## Land at Gosford

### Technical Note 13: Response to Active Travel England (ATE)

14<sup>th</sup> August 2023

- 1.1** Brookbanks is appointed by Barwood Development Securities Ltd to provide technical support for a proposed residential development at Gosford, Oxfordshire, which is the subject of a planning application (reference: 22/00747/OUT). The following development is proposed at the site:

Status		Status Date
Information		Feb 2022
Drawn	Checked	Date
HG	AE	22.02.22
Scale	Number	Rev
As shown	10669-SK-05	F
0 10 20 30 40 50		
METRES

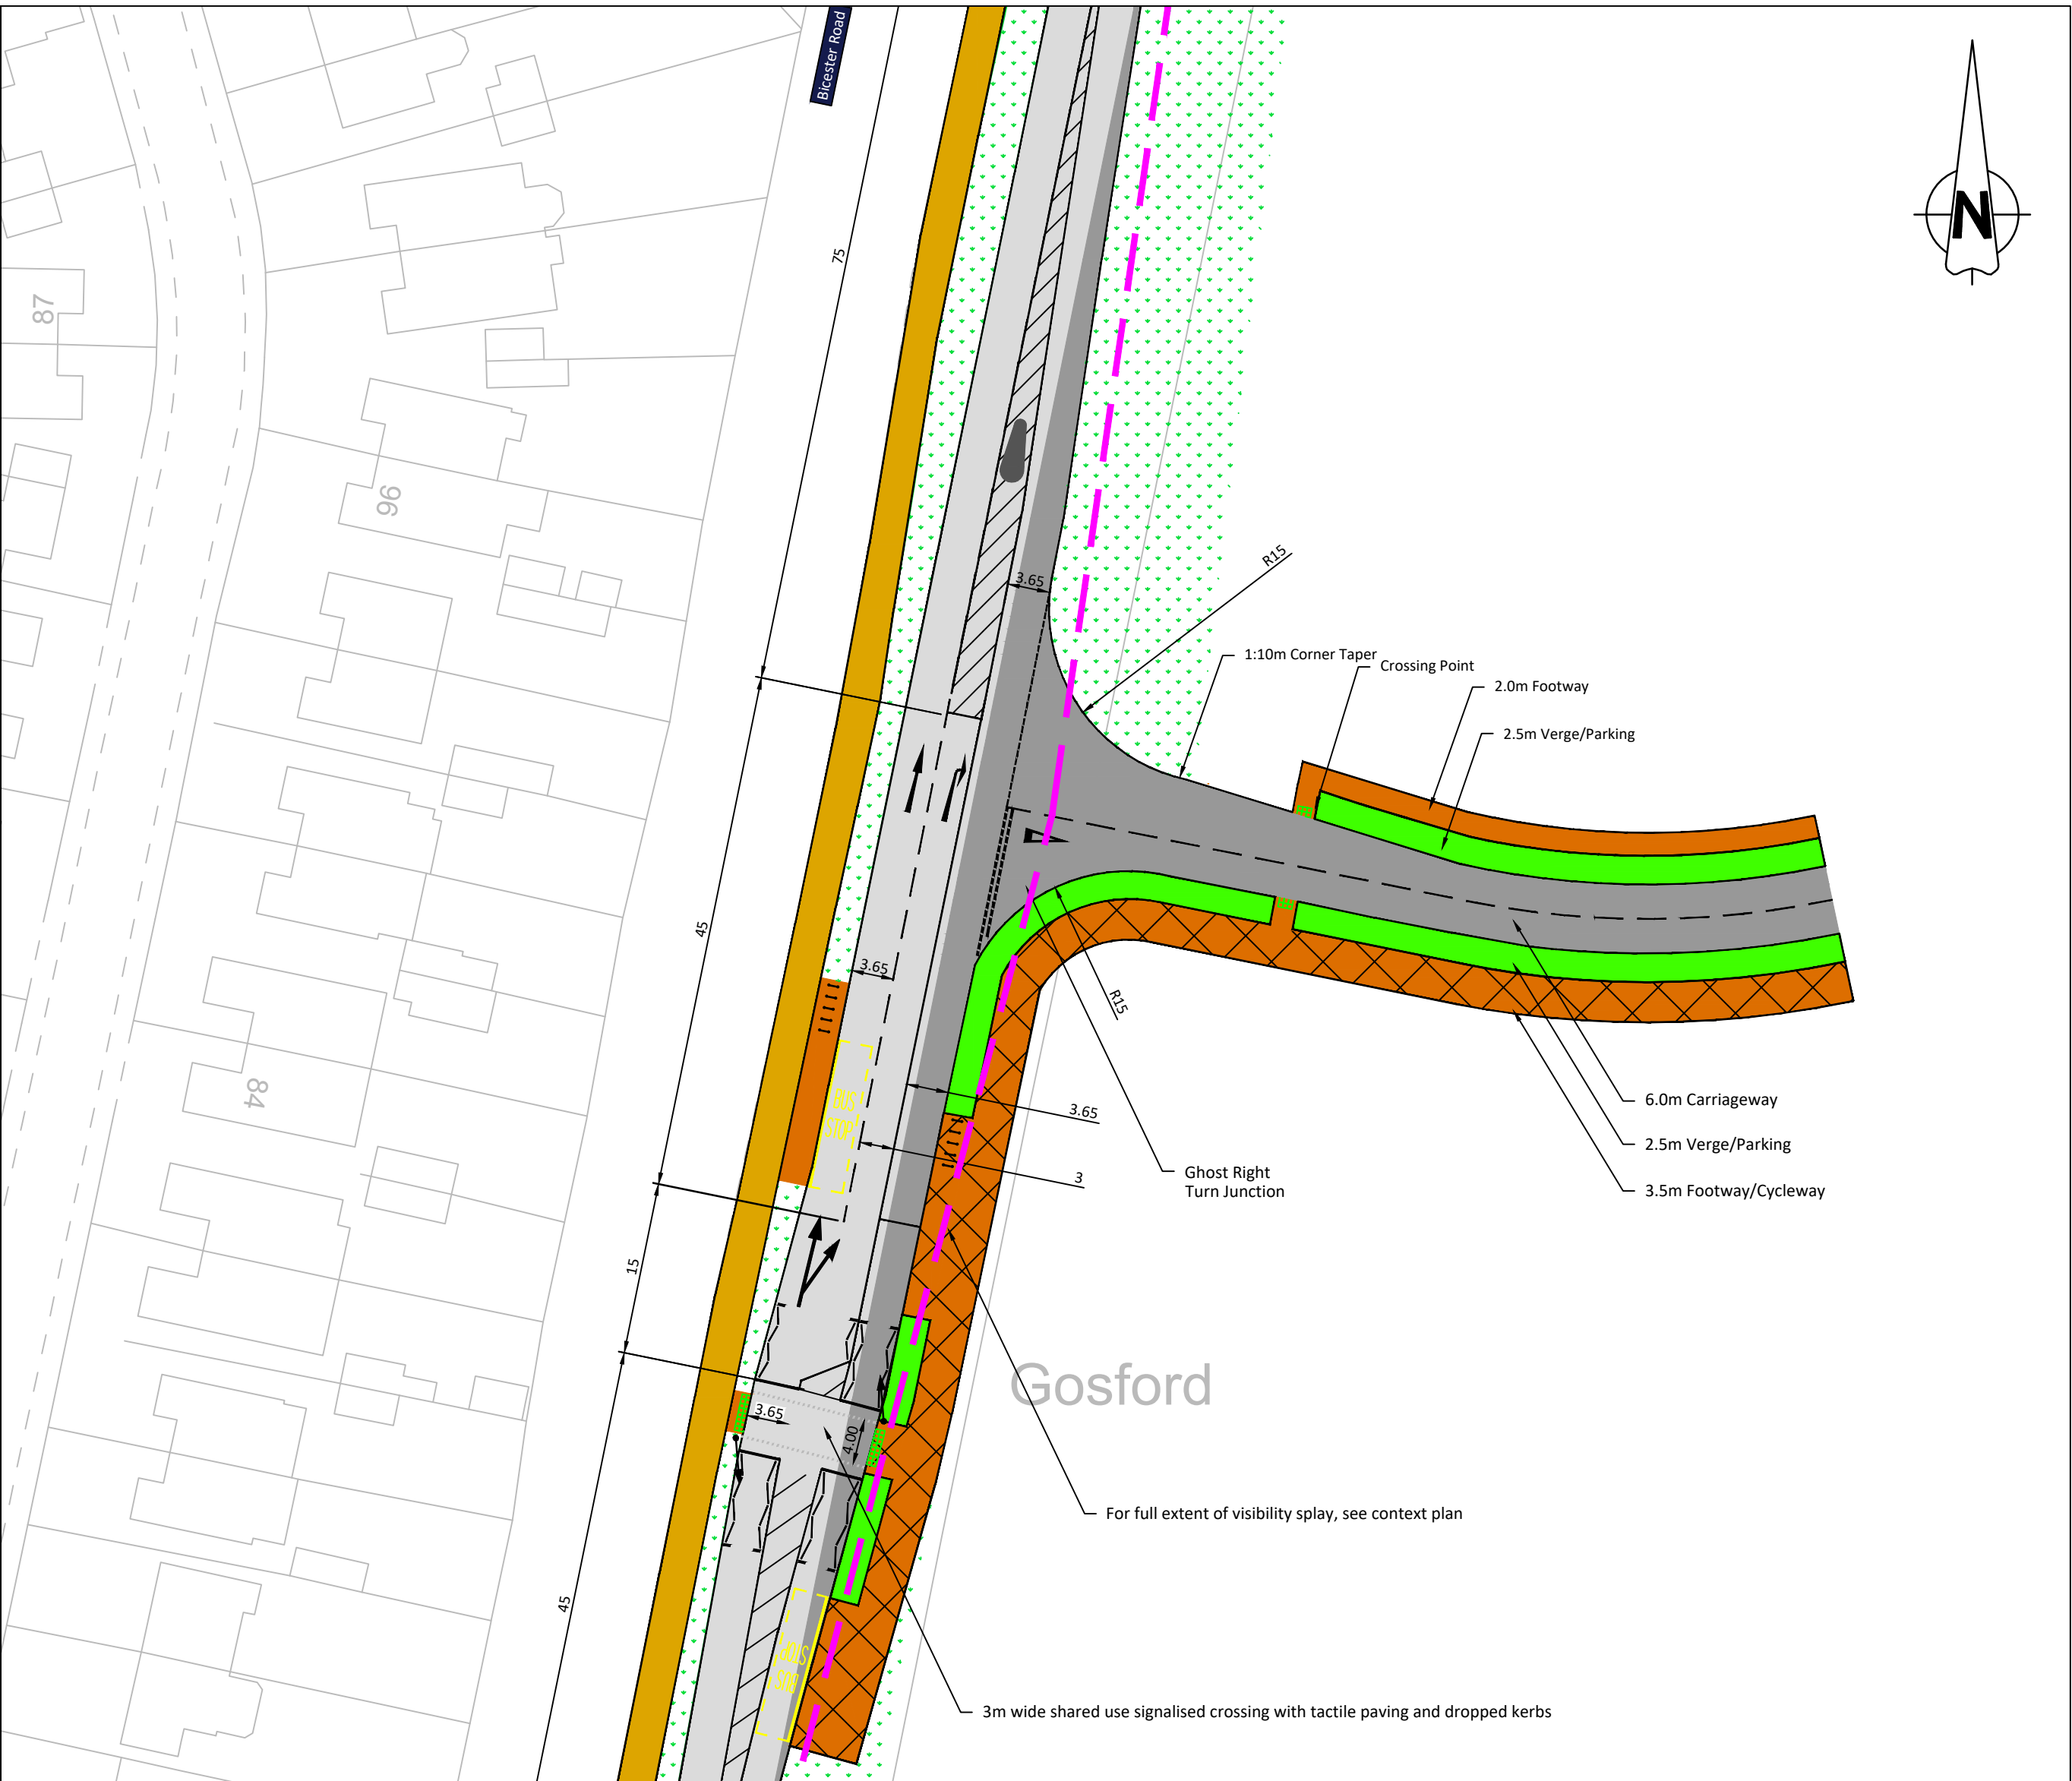
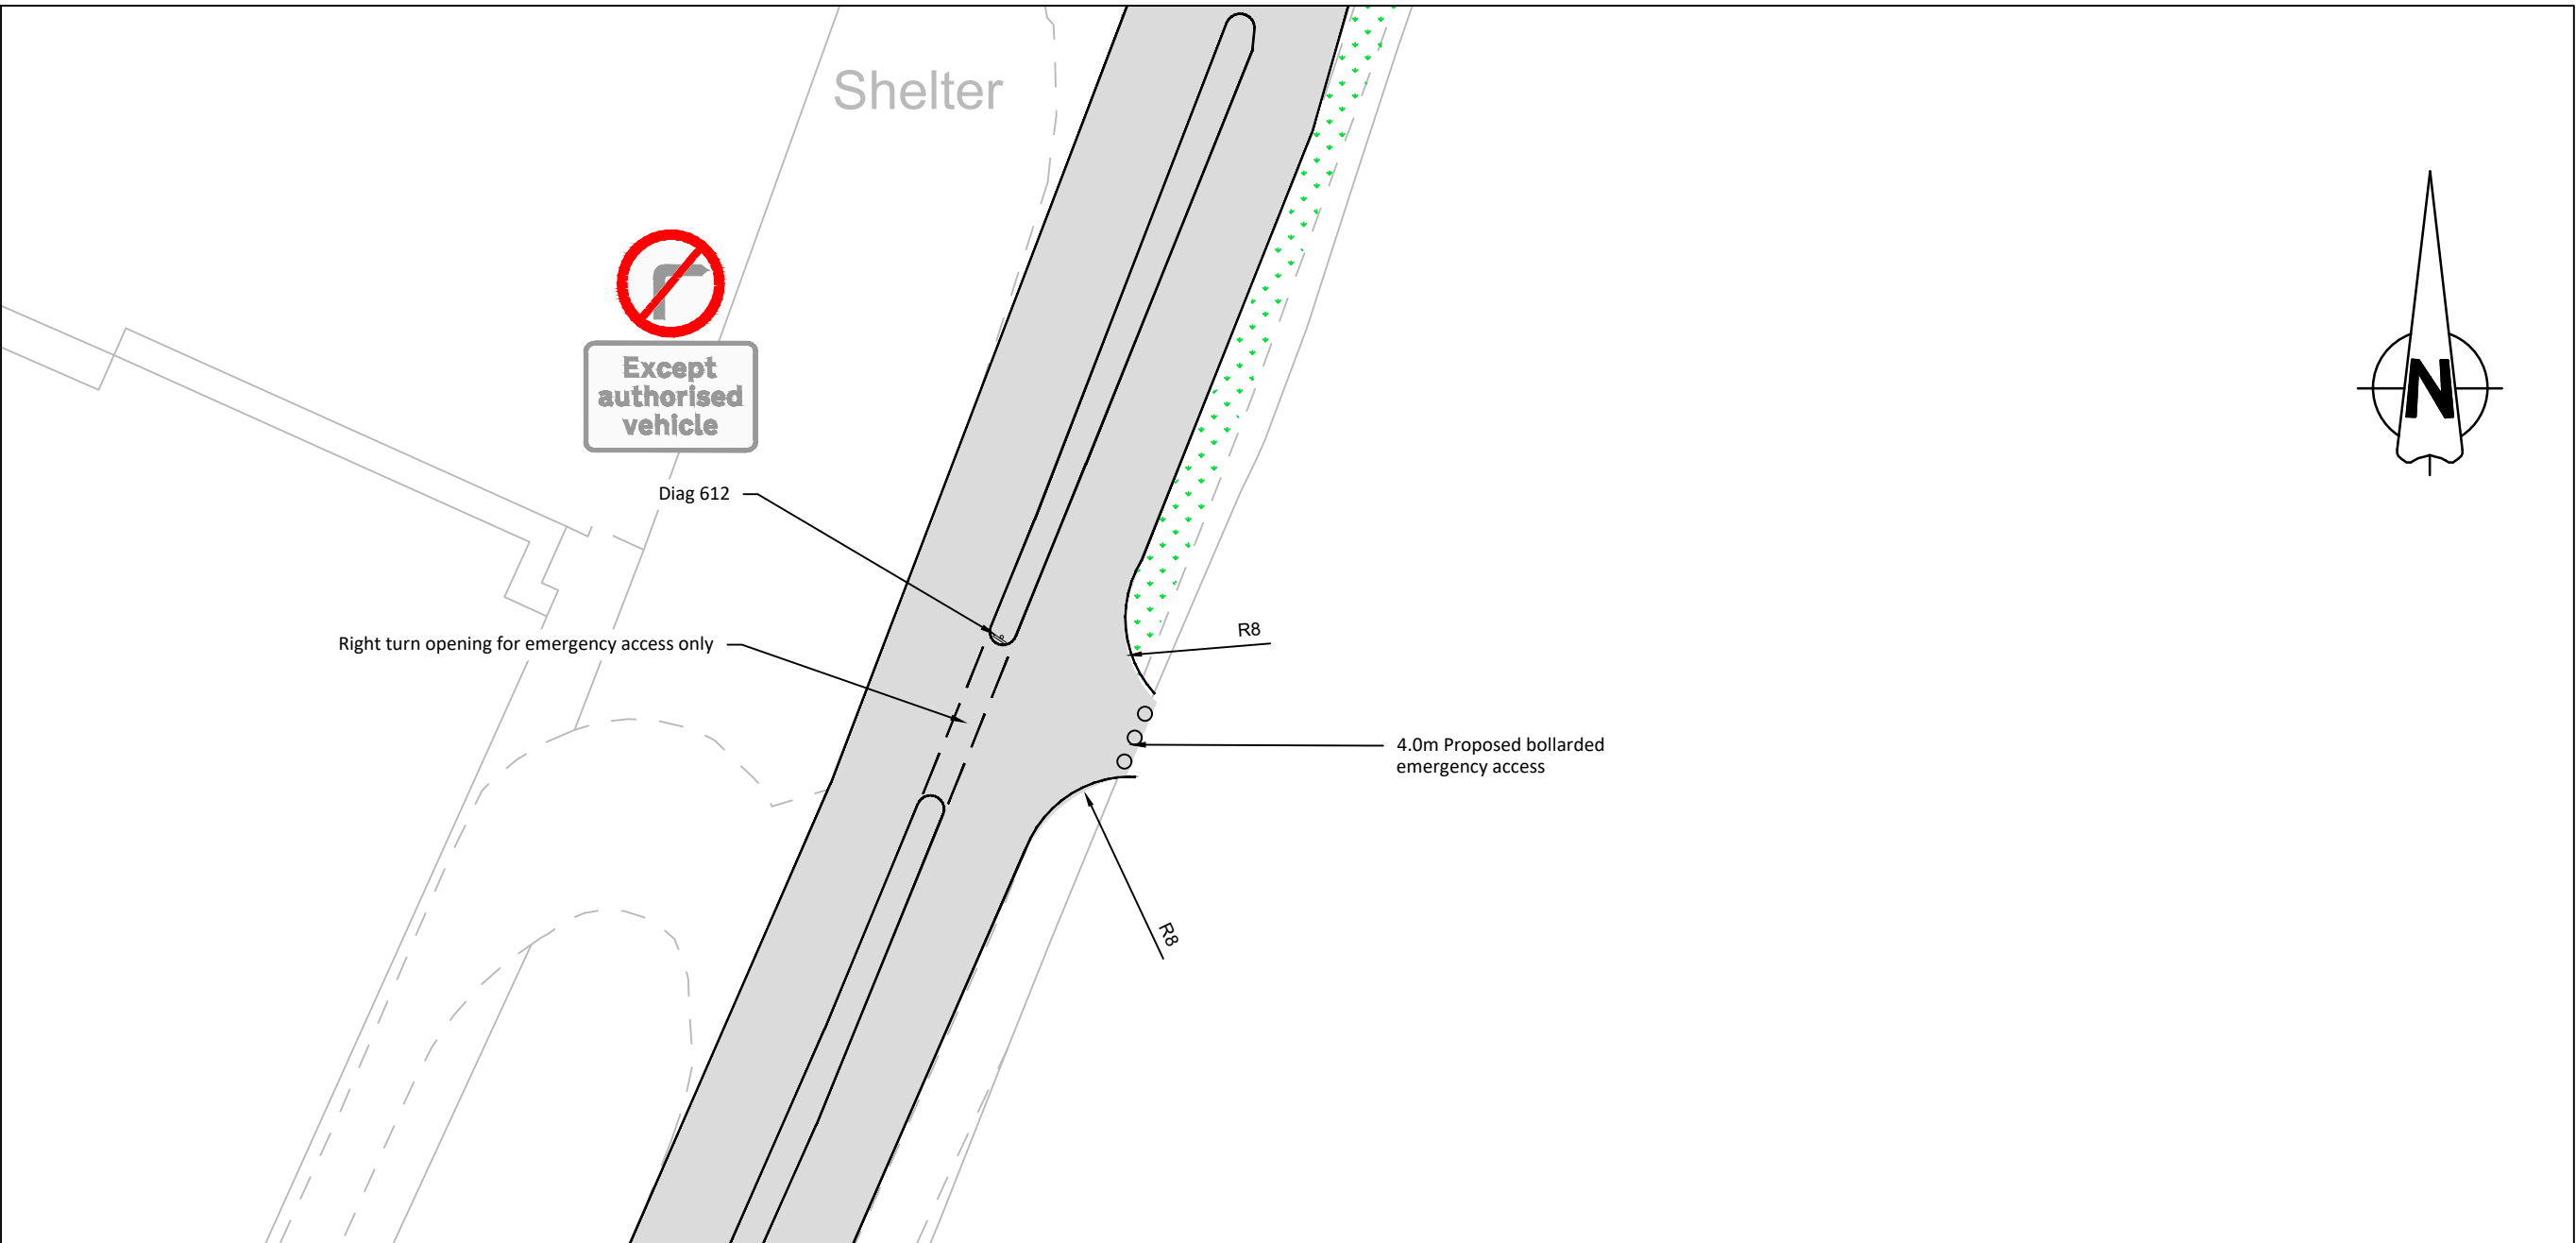
*ATE Comment: ATE notes that the pedestrian and cycle movements would be catered for through on and off-carriageway provision. However, the segregation provided to walkers, wheelers and cyclists is not clear. Bicester Road is currently limited to a single shared footway/cycleway on its western side. It requires users to cross the carriageway whether they are travelling north into Kidlington or South into Oxford. It is noted from the Transport Assessment that crossing points are to be provided across Bicester Road to access the existing footway/cycleway, and the location of a crossing is shown on drawing 10669-SK-05 included in the Transport Assessment, but the type of crossing is not specified. This design requires further consideration in accordance with LTN1/20.*

*ATE Comment: In accordance with paragraph 104 of the NPPF, Active Travel England notes the location of the proposed pedestrian crossing in the Transport Assessment (drawing 10669-SK05) and would welcome further detail on the type of crossing to ensure its suitability for all users.*

- 3.3 The connections along Bicester Road have also been raised by OCC. The access drawing has subsequently been updated, 10669-SK-05F, which confirms that the crossings along Bicester Road will be signalised, as confirmed in paragraph 3.7 of 10669TNH11vRev1. The amended site access drawing is contained in **Appendix A**. A Road Safety Audit has been completed that reviewed the site access arrangements with the full details provided within the TA Addendum.

- 3.9** As previously indicated, crossing facilities along Bicester Road are to be delivered. These are to be signalised crossing points which complies to LTN 1/20. These are indicated on the site access drawing 10669-SK-05F, which is contained in **Appendix A**.

- 3.10** As previously indicated, the crossing facilities along Bicester Road are to be signalised. These are indicated on the site access drawing 10669-SK-05F which is contained in **Appendix A**.
